**From:** [Harmon Rita T.](#)  
**To:** ["rhdenineering@outlook.com"](mailto:rhdenineering@outlook.com)  
**Cc:** [Elliott, Stanice](#)  
**Subject:** J22D012A - Monterey Baptist Church (Stamp Date: 6-17-15)  
**Date:** Monday, February 01, 2016 10:04:08 AM

Based upon the information provided in your submittal received 1-28-2016, the above referenced plan cannot be approved for Certification of Occupancy by Hydrology until the following comments are addressed:

ENGINEER'S SEAL	DRAWN BY	DATE 5-2015
	Monterey Baptist Church	GRADING AND DRAINAGE PLAN	SHEET # 1 of 2
Richard Dourte P.E. #10854	RHD Engineering, LLC 4305 Purple Sage Ave. NW ALBUQUERQUE, NM 87120 (505) 288-1621	JOB #

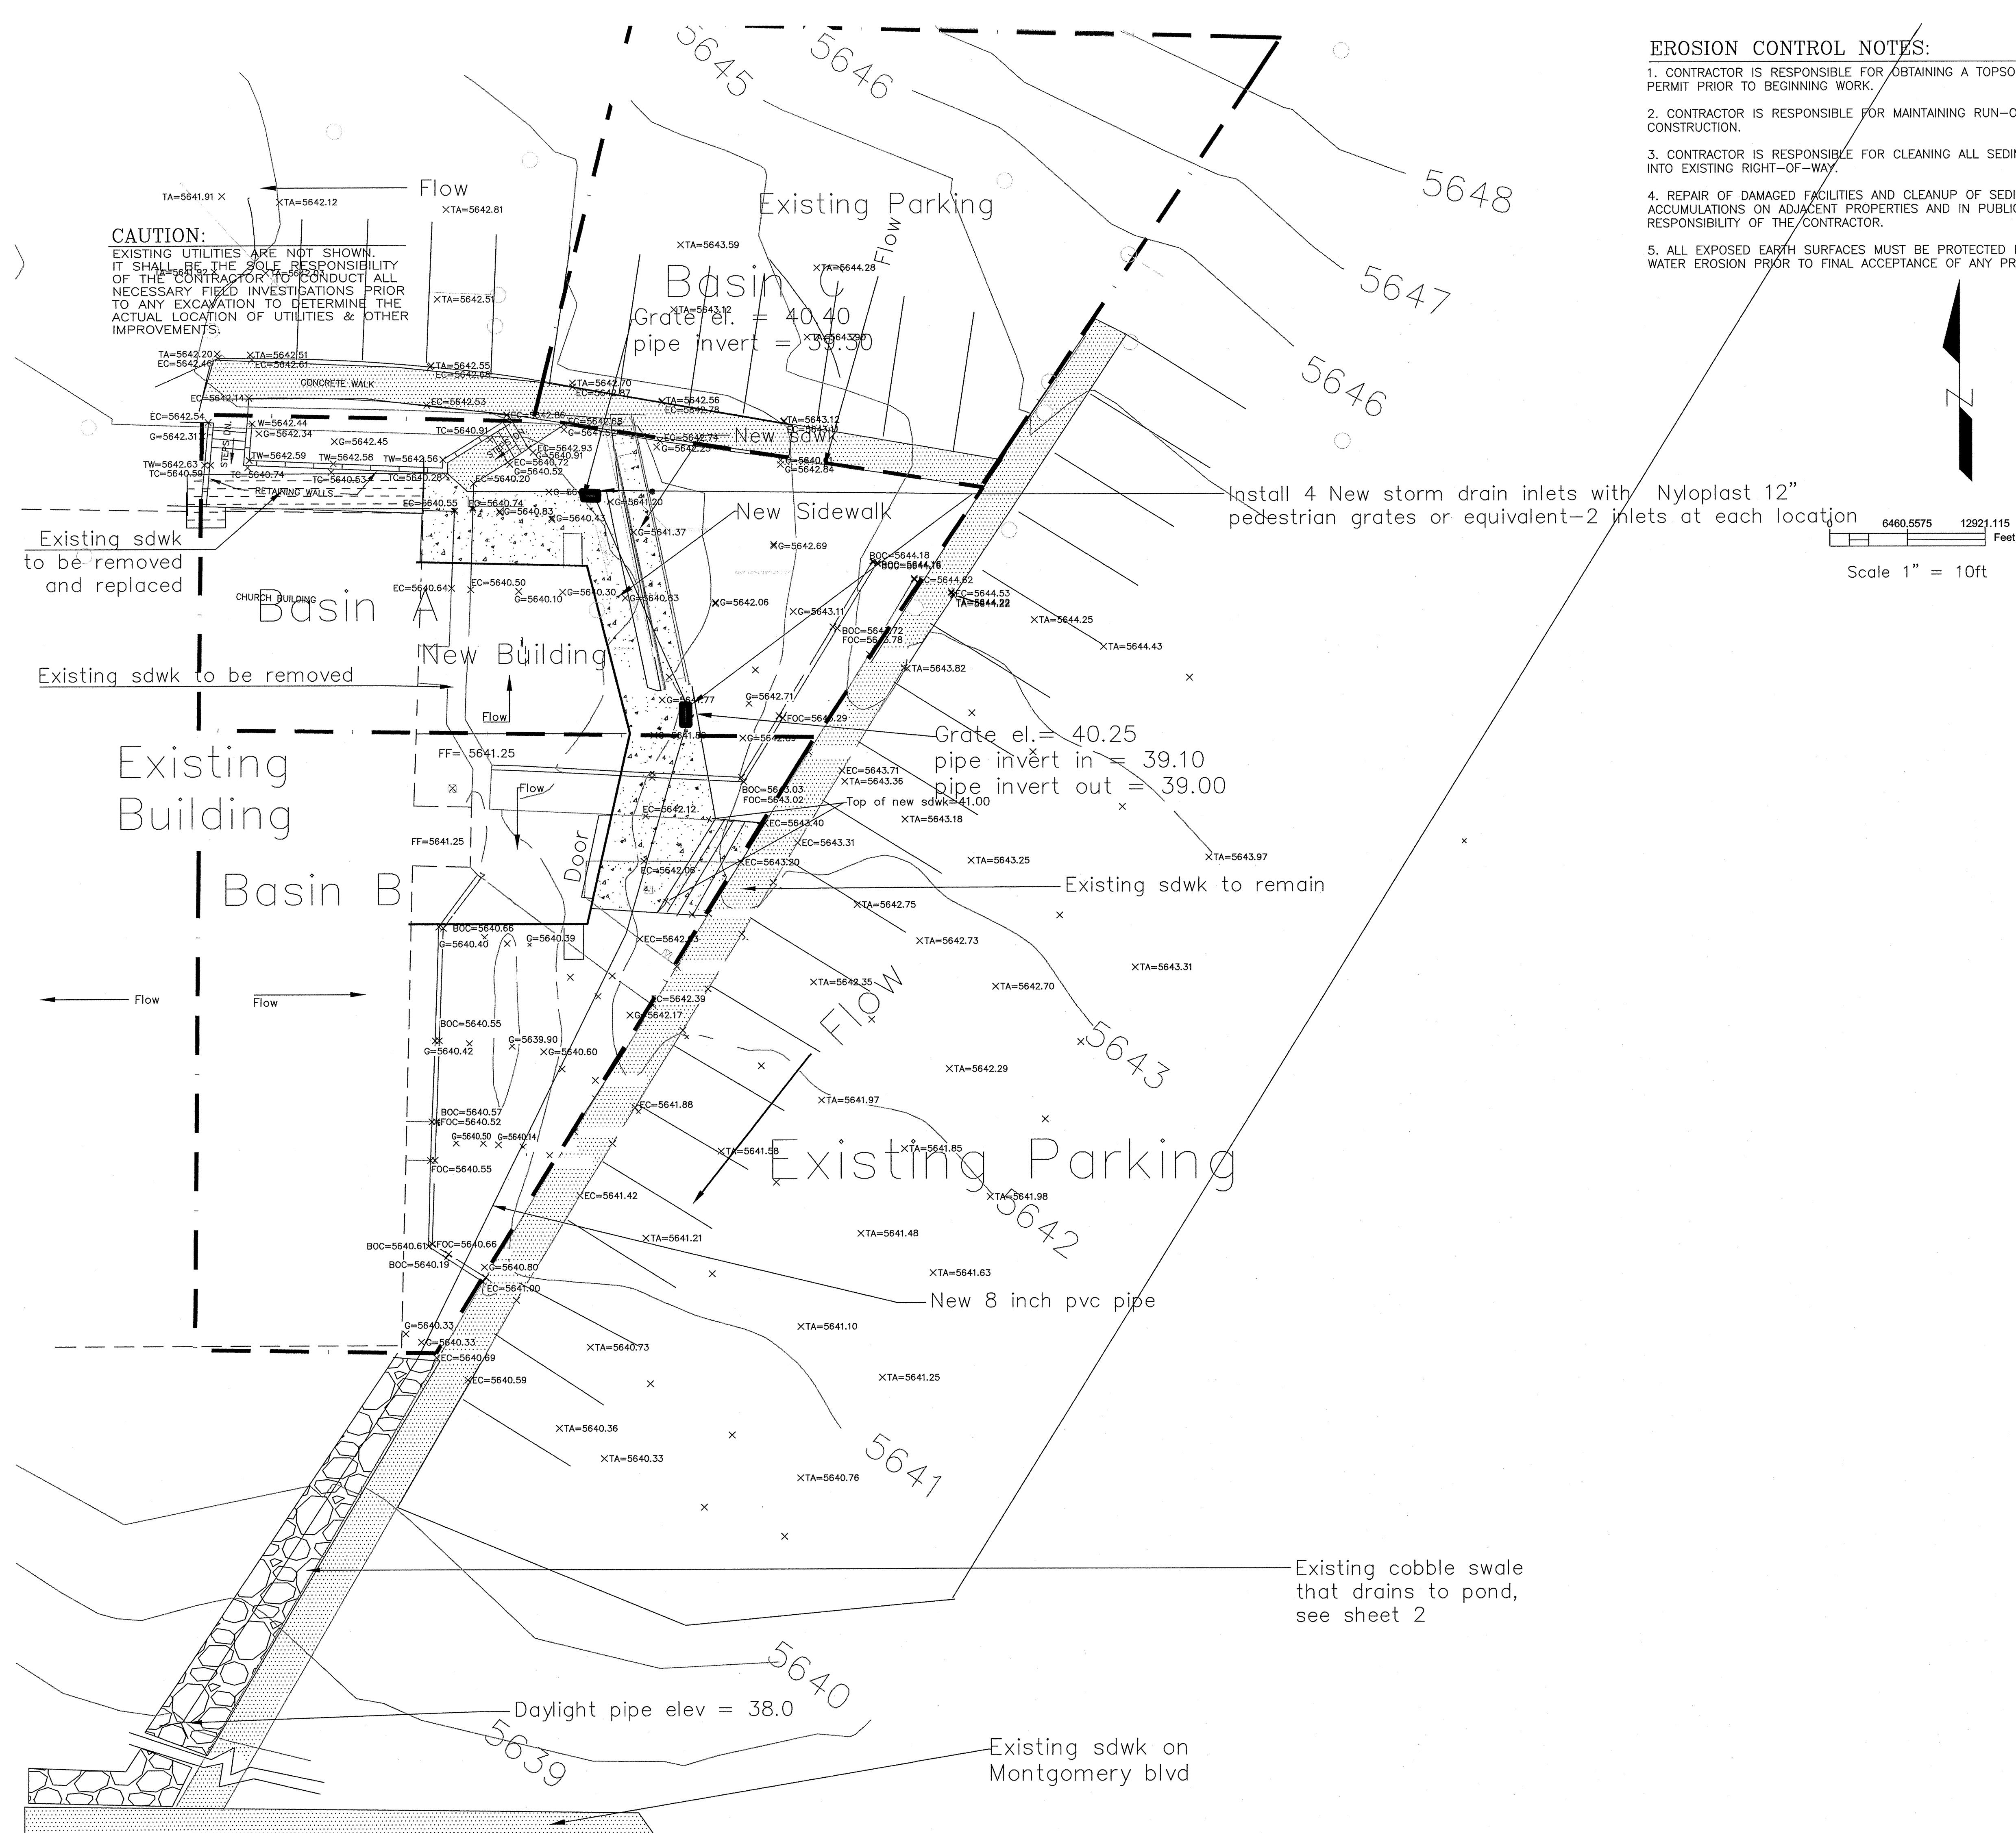
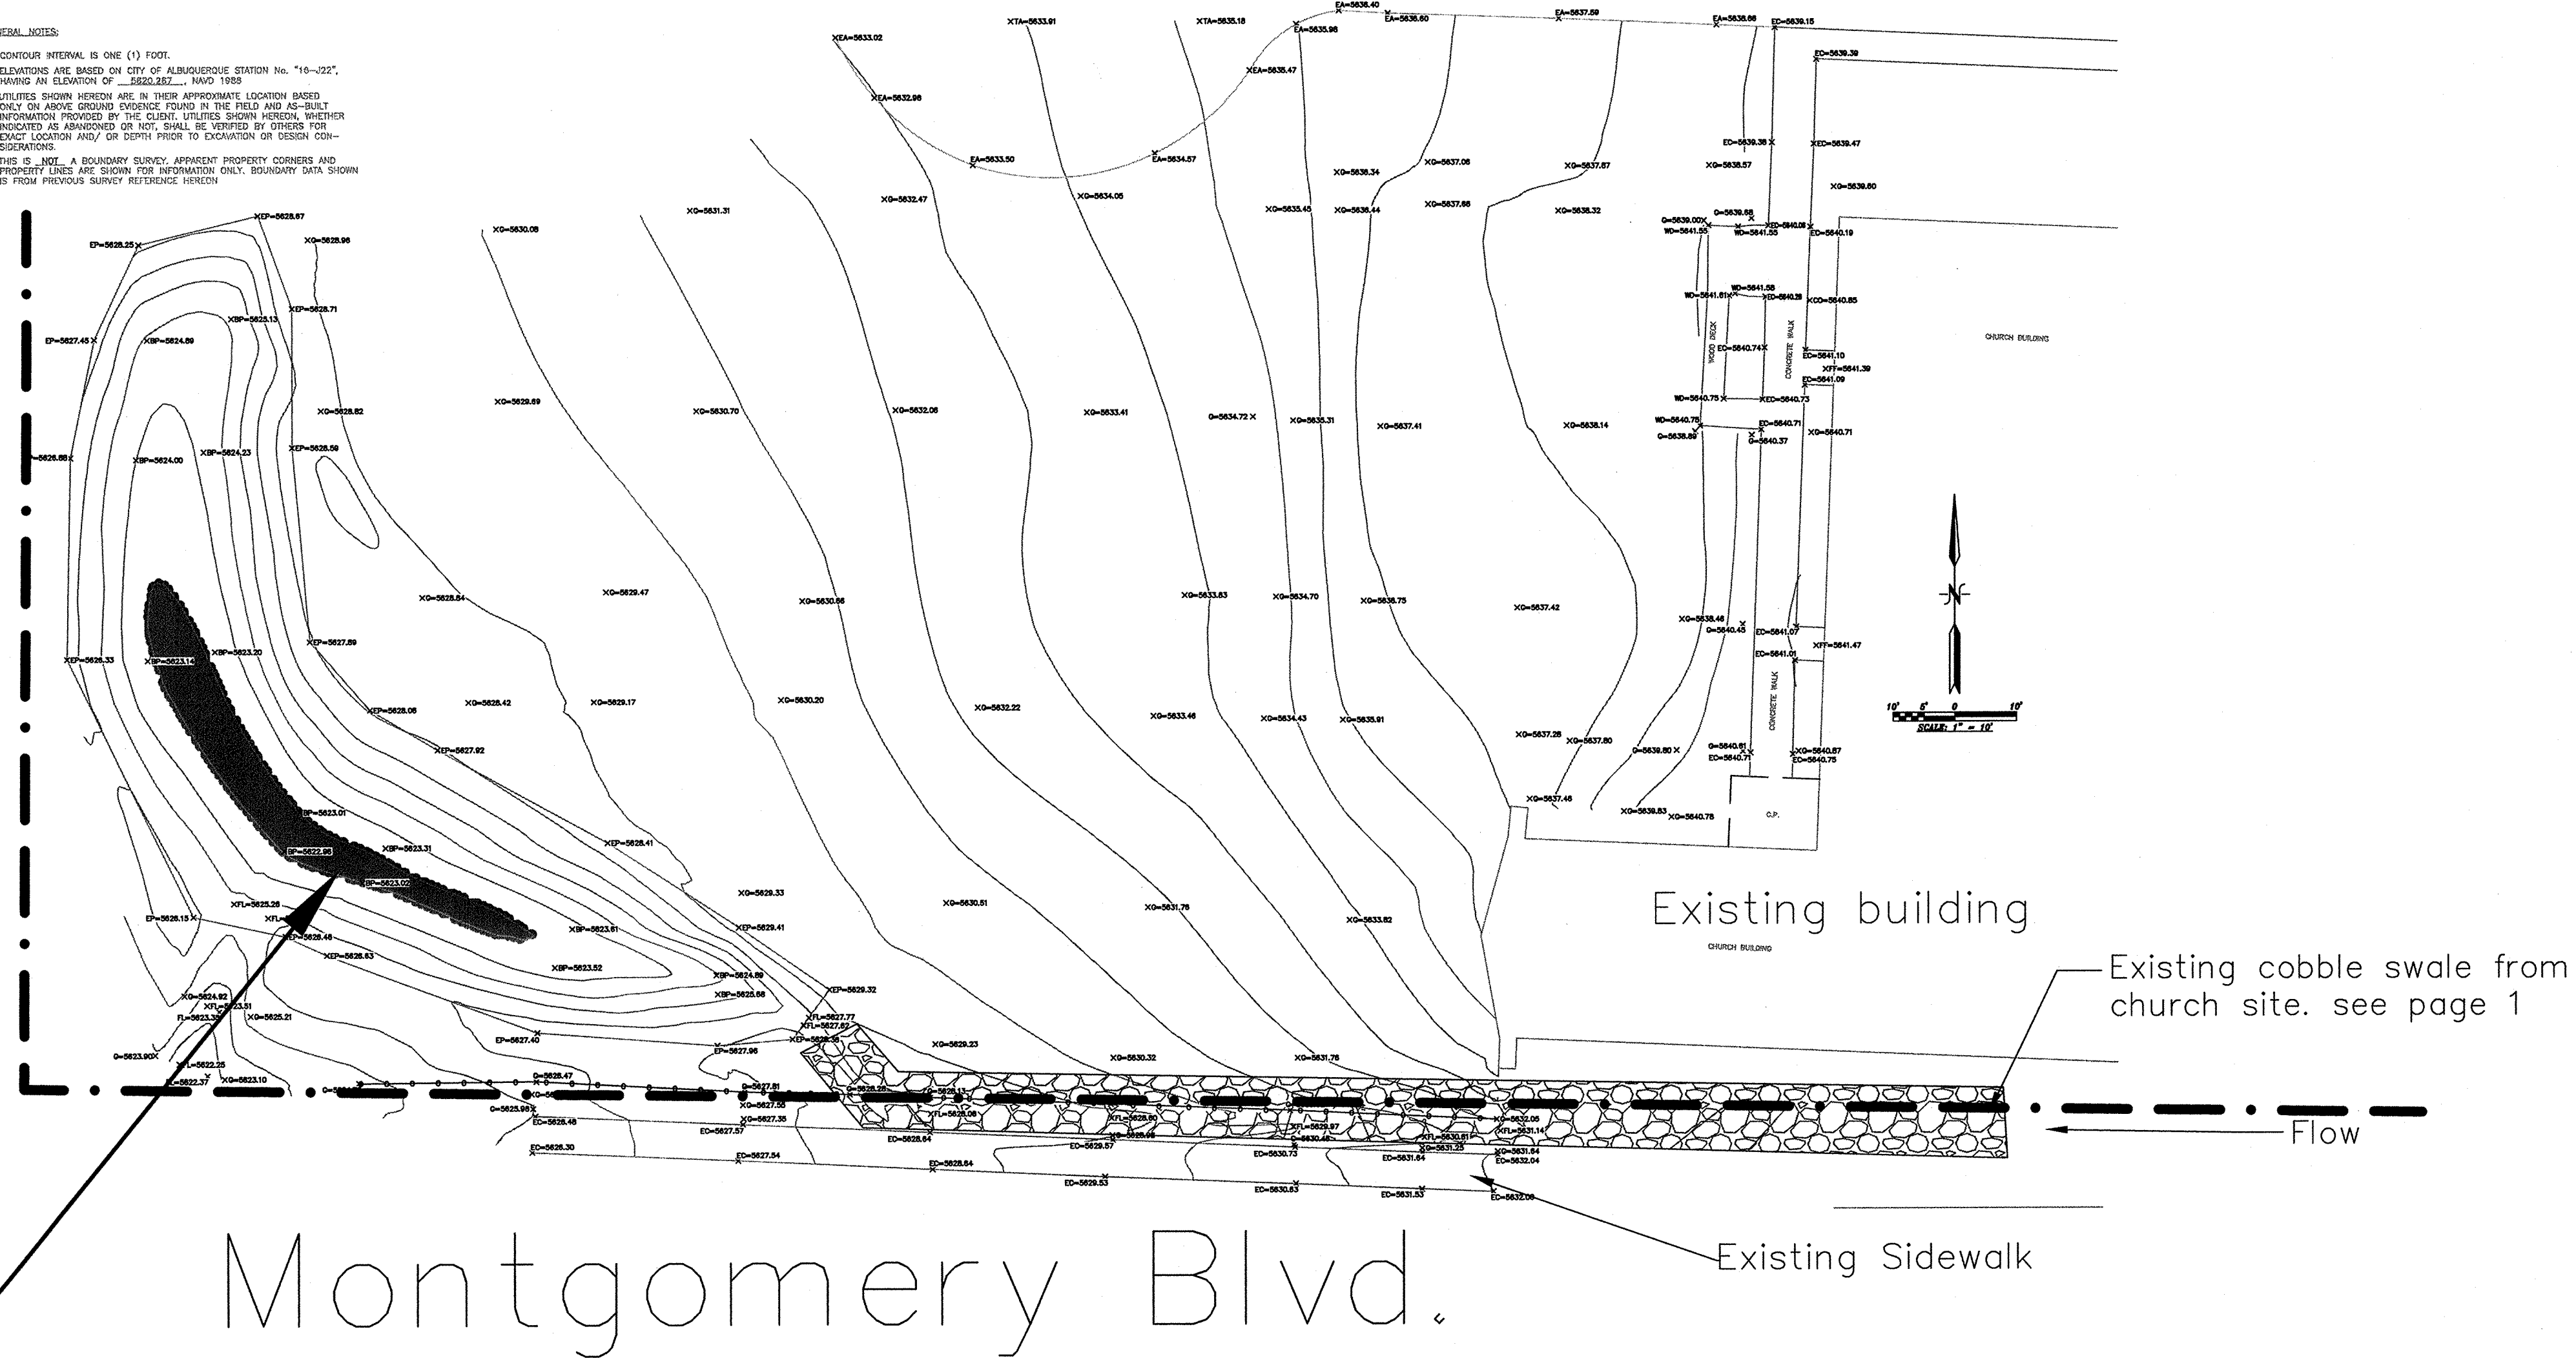
- A portion of the existing cobble swale that connects to the new pond has been removed and is missing.
